# Eldorado Springs at Cheyenne Mountain Fil. No. 1

## ADMINISTRATIVE SITE DEVELOPMENT PLAN - SITE LIGHTING PLAN

# Lighting Plan\_V2.pdf Markup Summary

SITE LIGHTING PLAN
SDP16
SHEET 16 OF 16
ALC PROJECT # 19-020

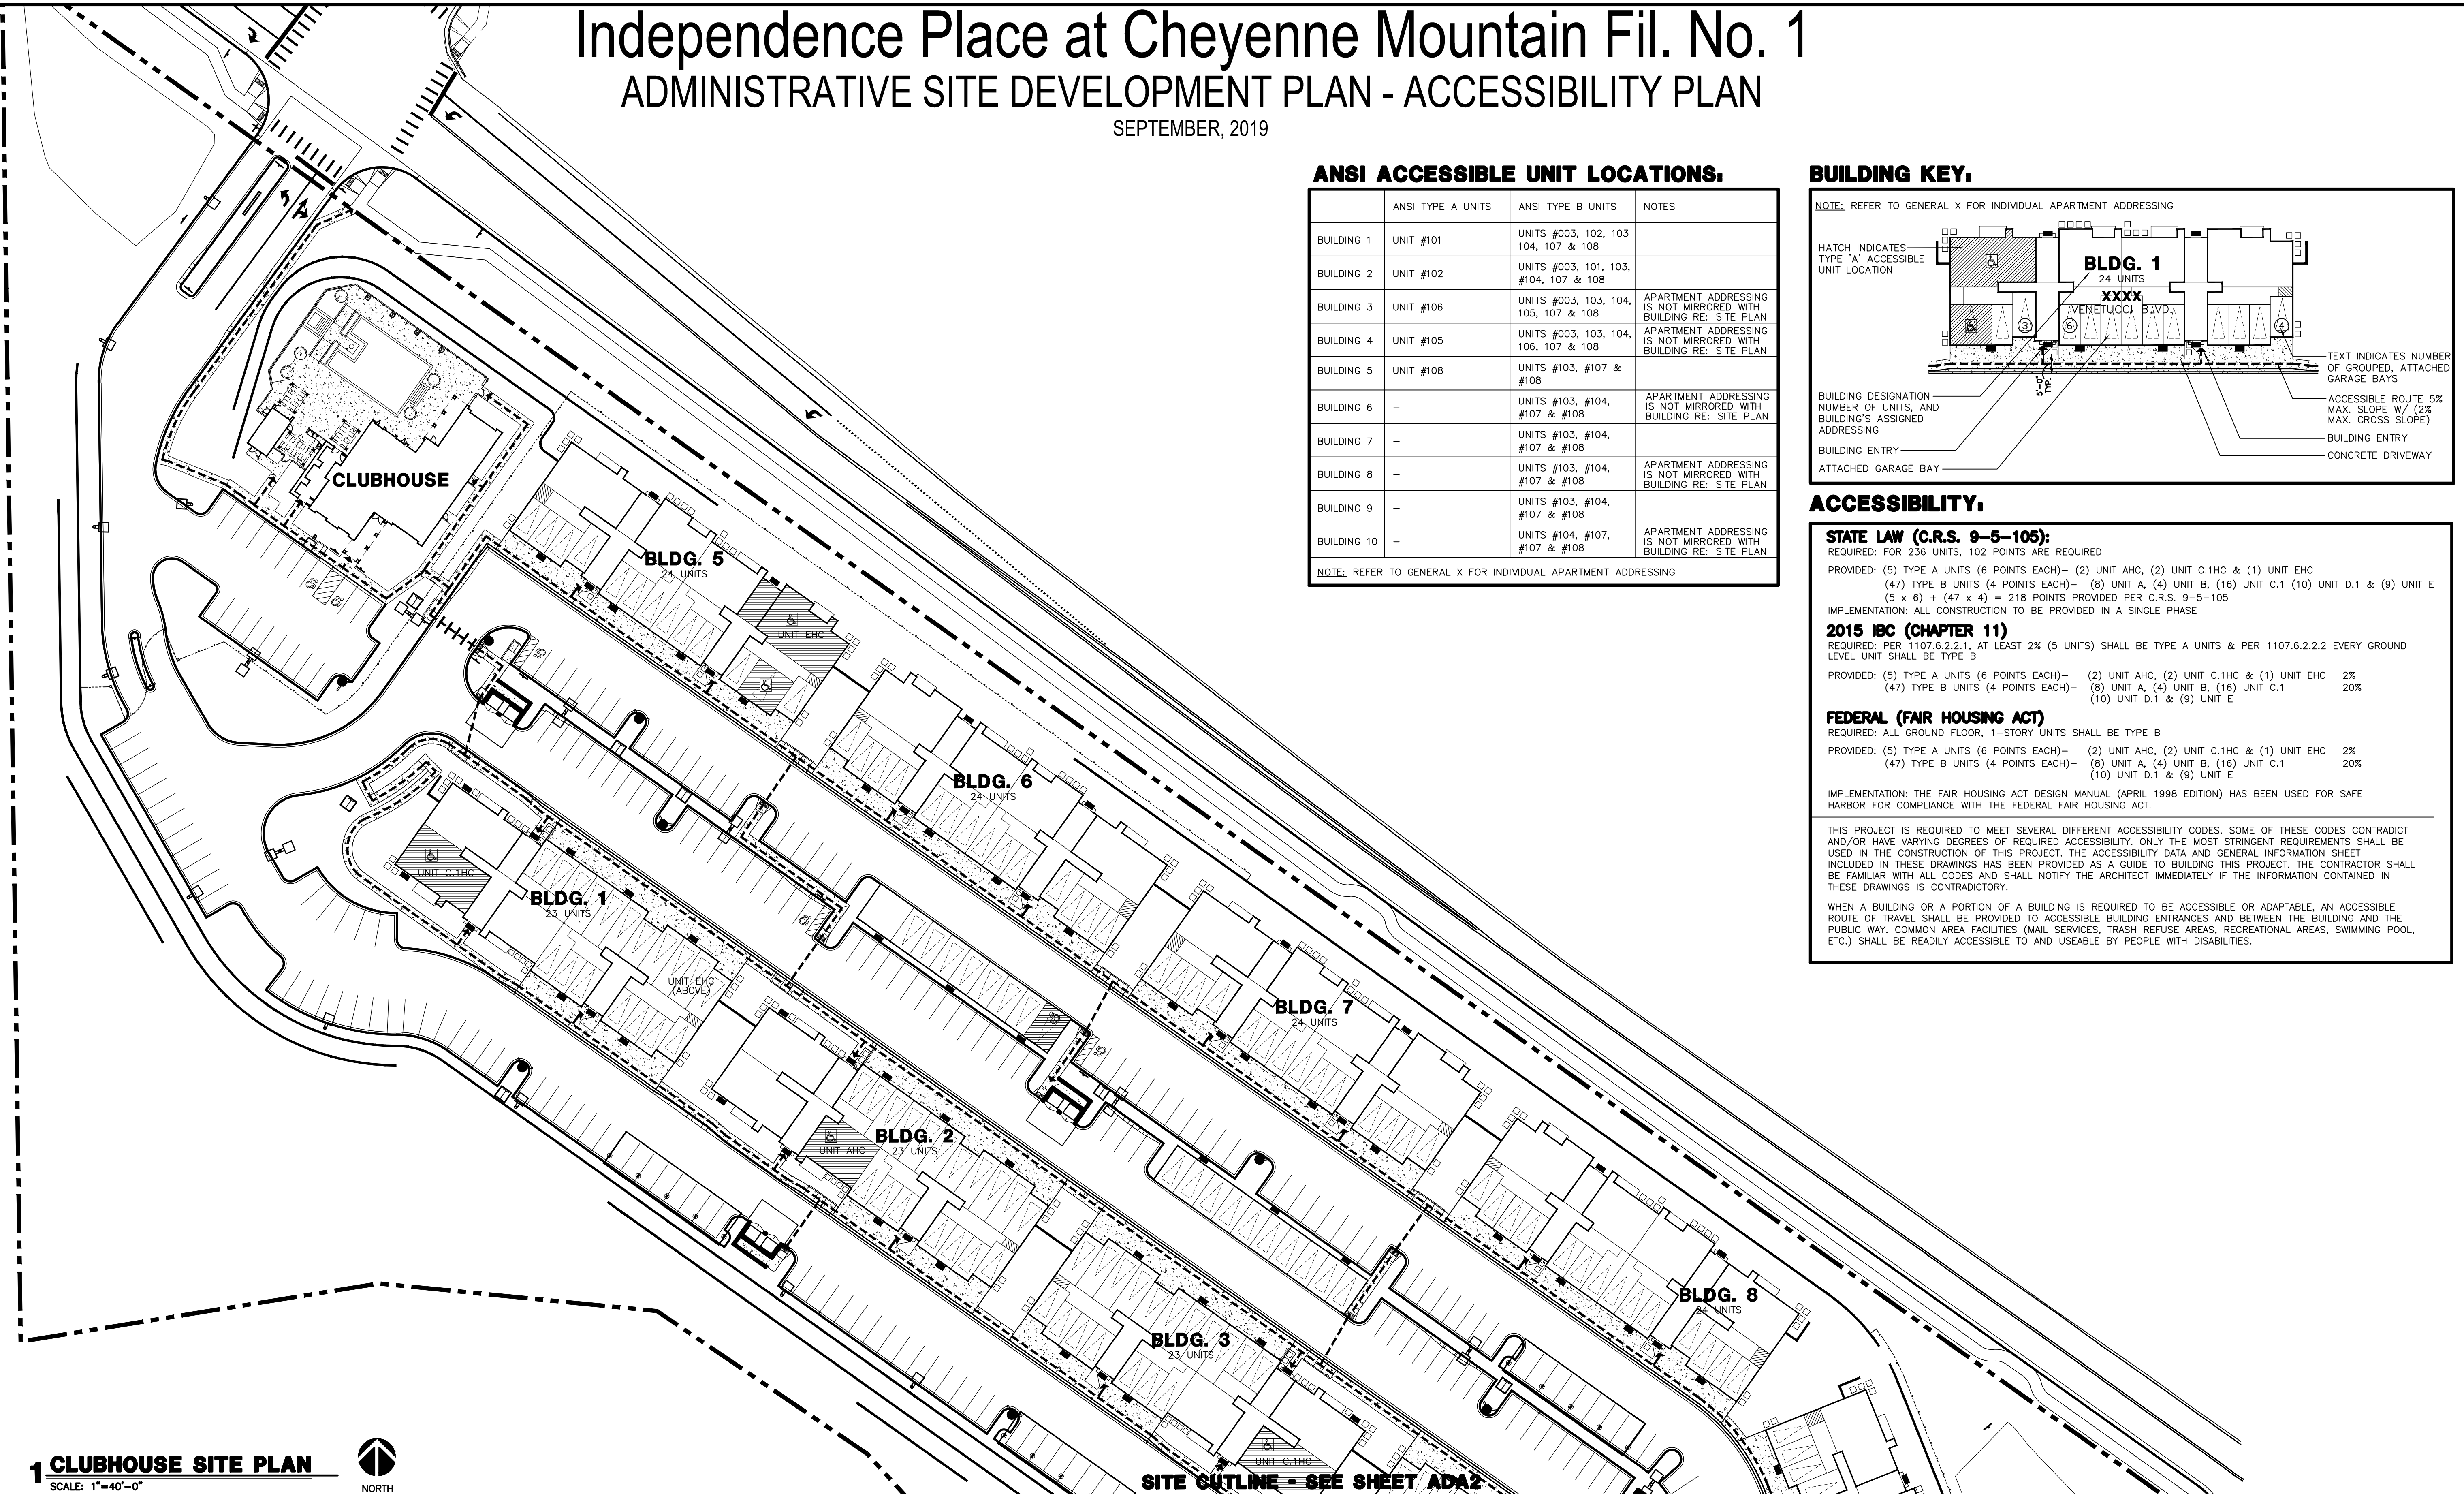
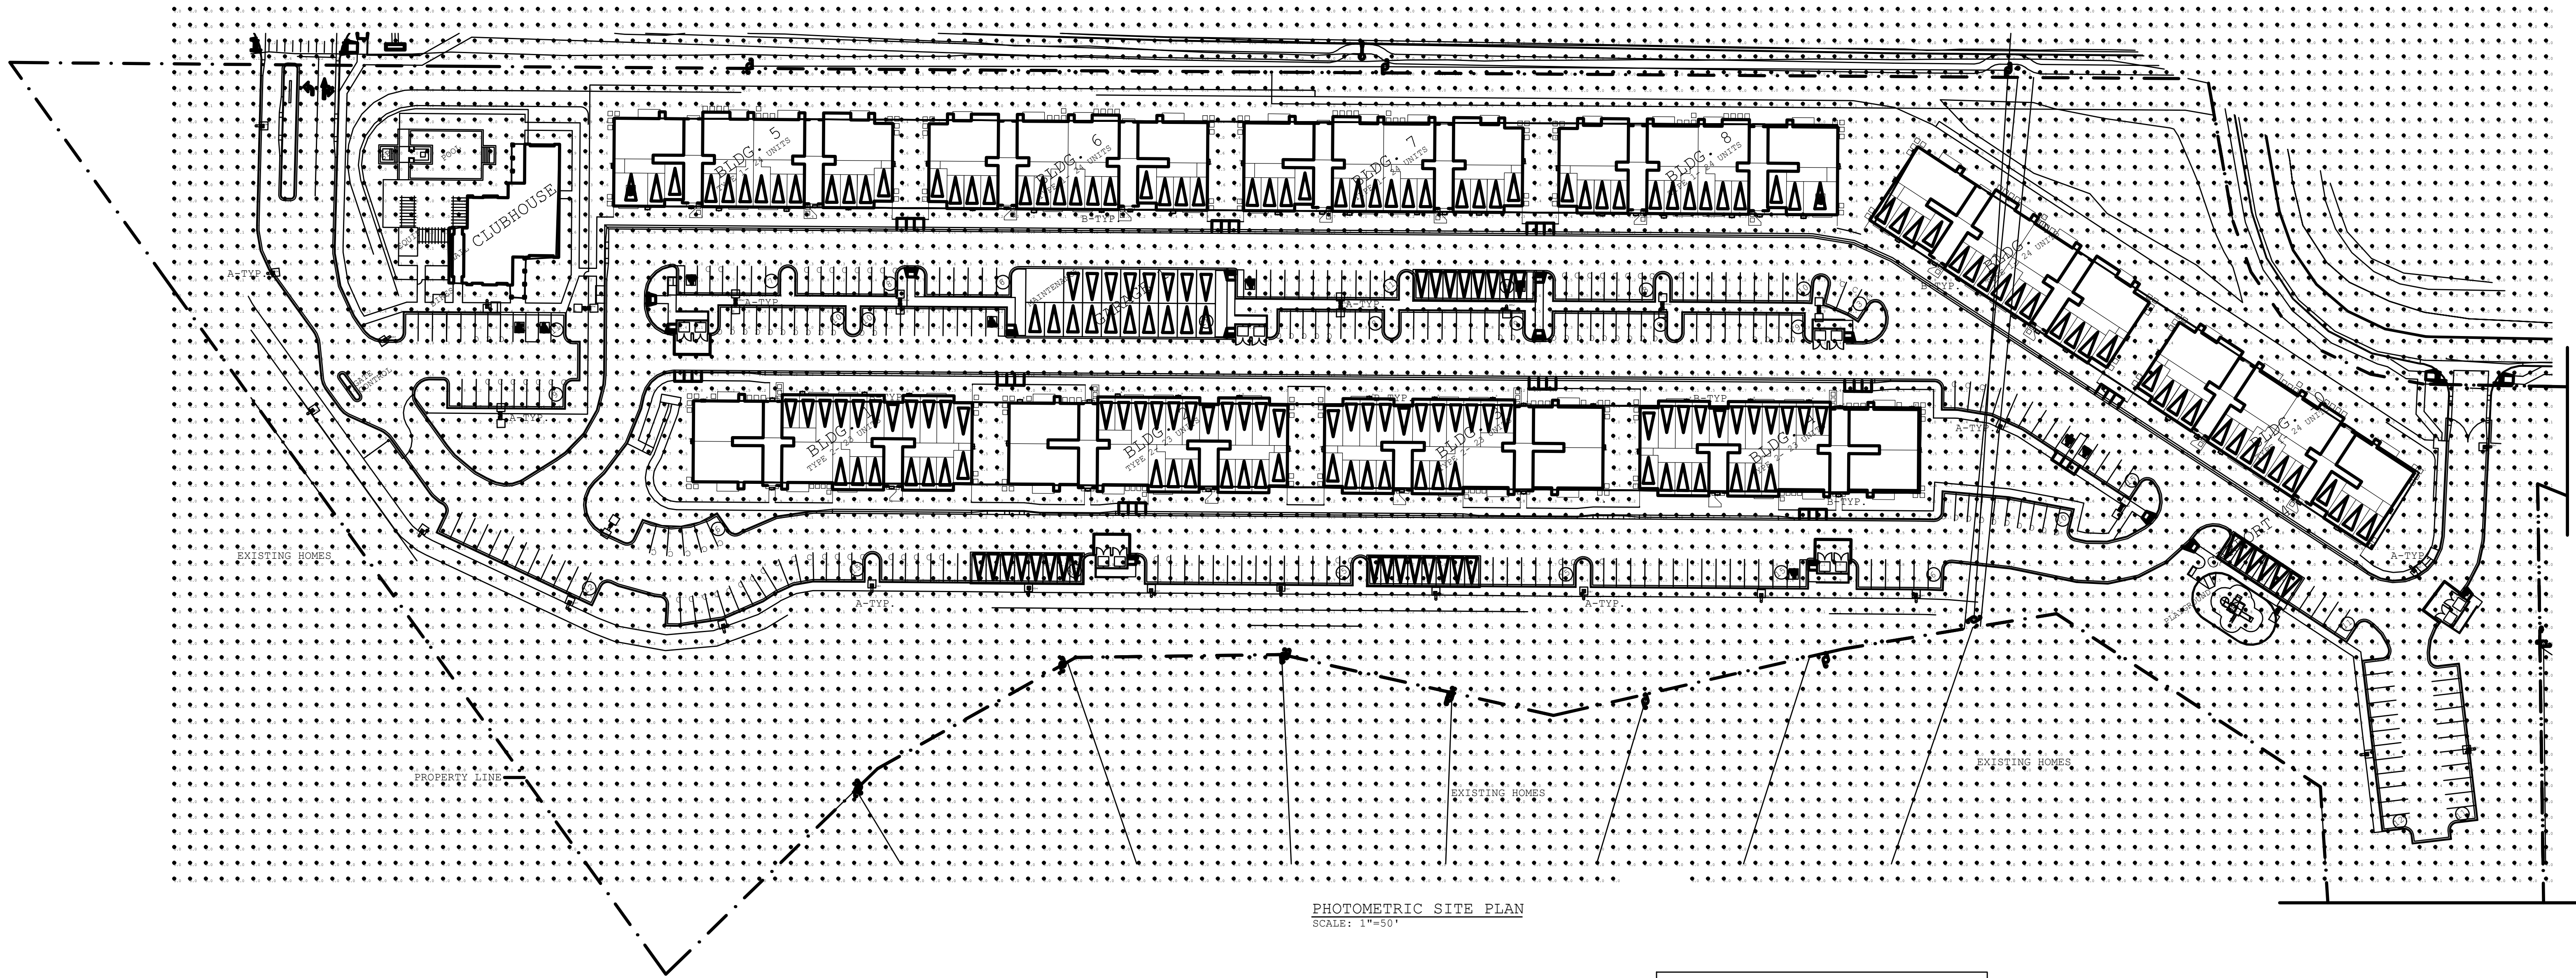
update, needs to be  
INDEPENDENCE  
PLACE AT  
CHEYENNE  
MOUNTAIN FIL NO 1

update, needs to be INDEPENDENCE PLACE AT  
CHEYENNE MOUNTAIN FIL NO 1
